Date: December 22, 2014

Address: 30 Monvment St

CHECK-LIST AGAINST ZONING ORDINANCE

Proposed Use/Work - build new 22x48 single family

SHEET TITLE:
PROPOSED SITE PLAN

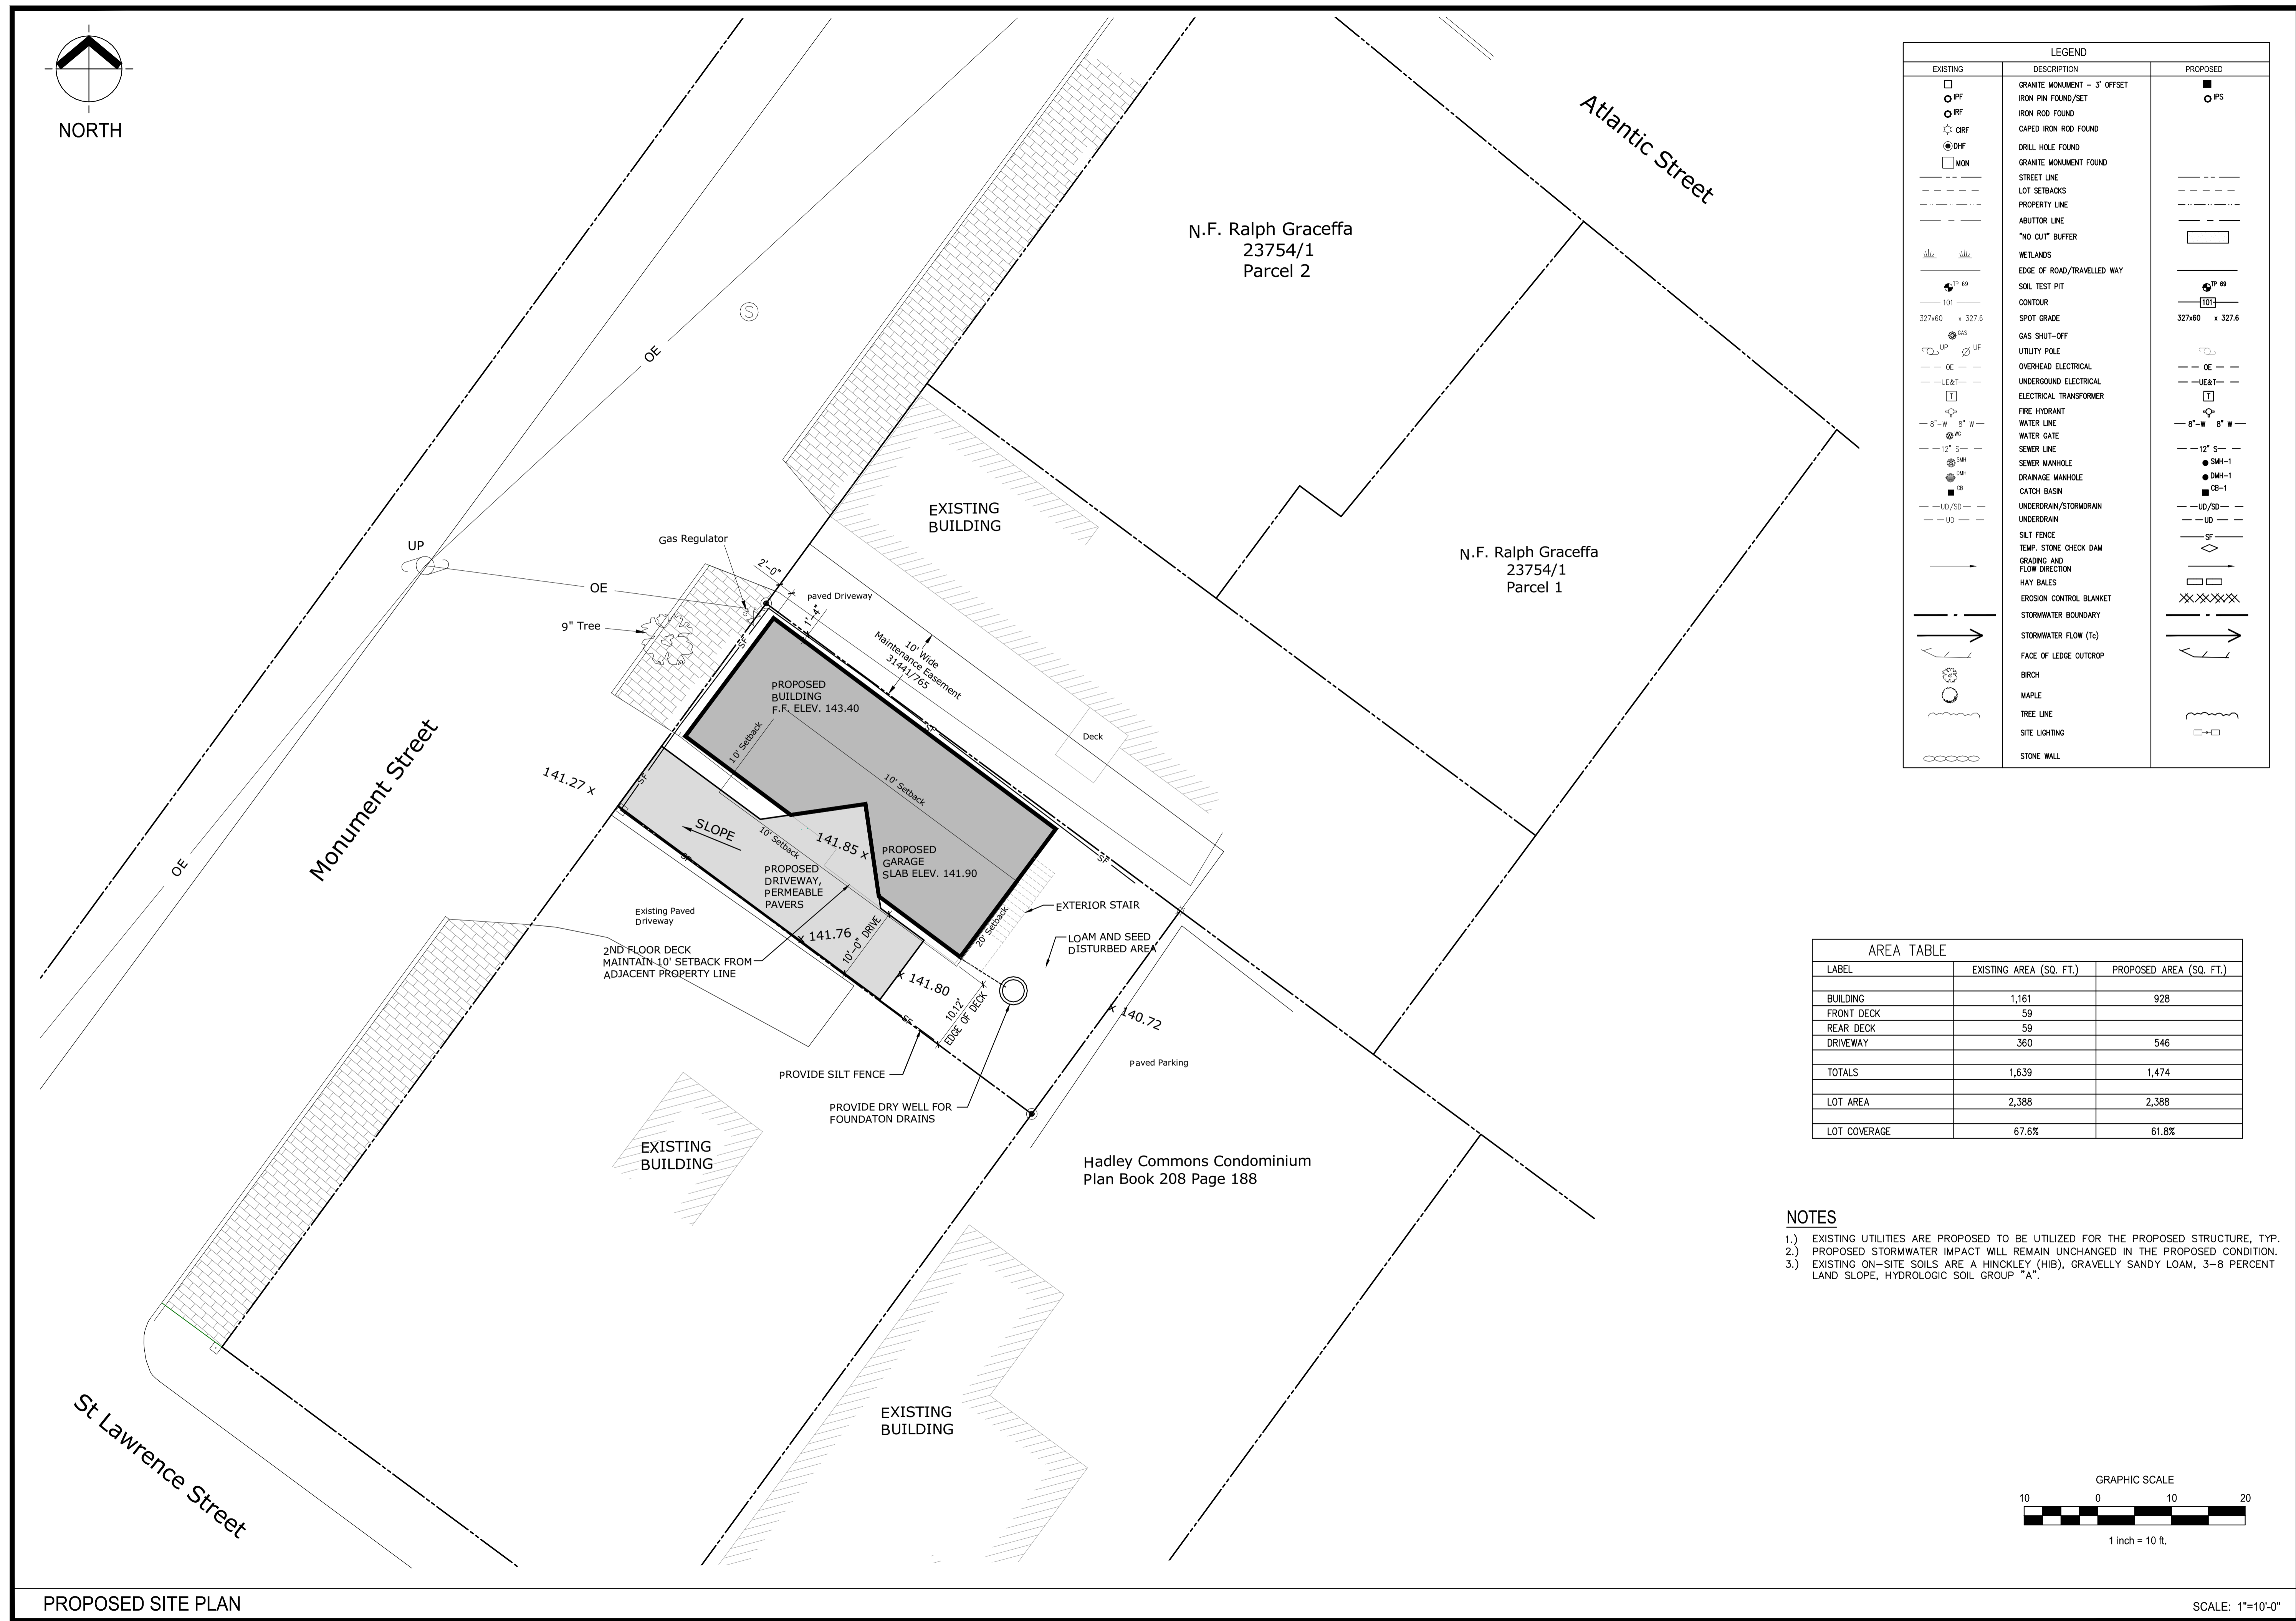
Front Yard - rebuilding in same footprint on front. 0 setback - 10' or average.

Rear Yard - 20' min. - ~~20' setback~~ 16.75 to rear stairs

- section 14-~~436~~ 385 allows nonconforming structure (setbacks & land area) due to decay same footprint & shell - rebuild within year.

Side Yard - 10' min. - ~~10.11' or 11.75' on right~~ OK - because within original footprint

Projections - left side is existing - new 1' off.

Lot Coverage Impervious Surface - 50% = 1190 sq ft

20% open space 476 sq ft OK -
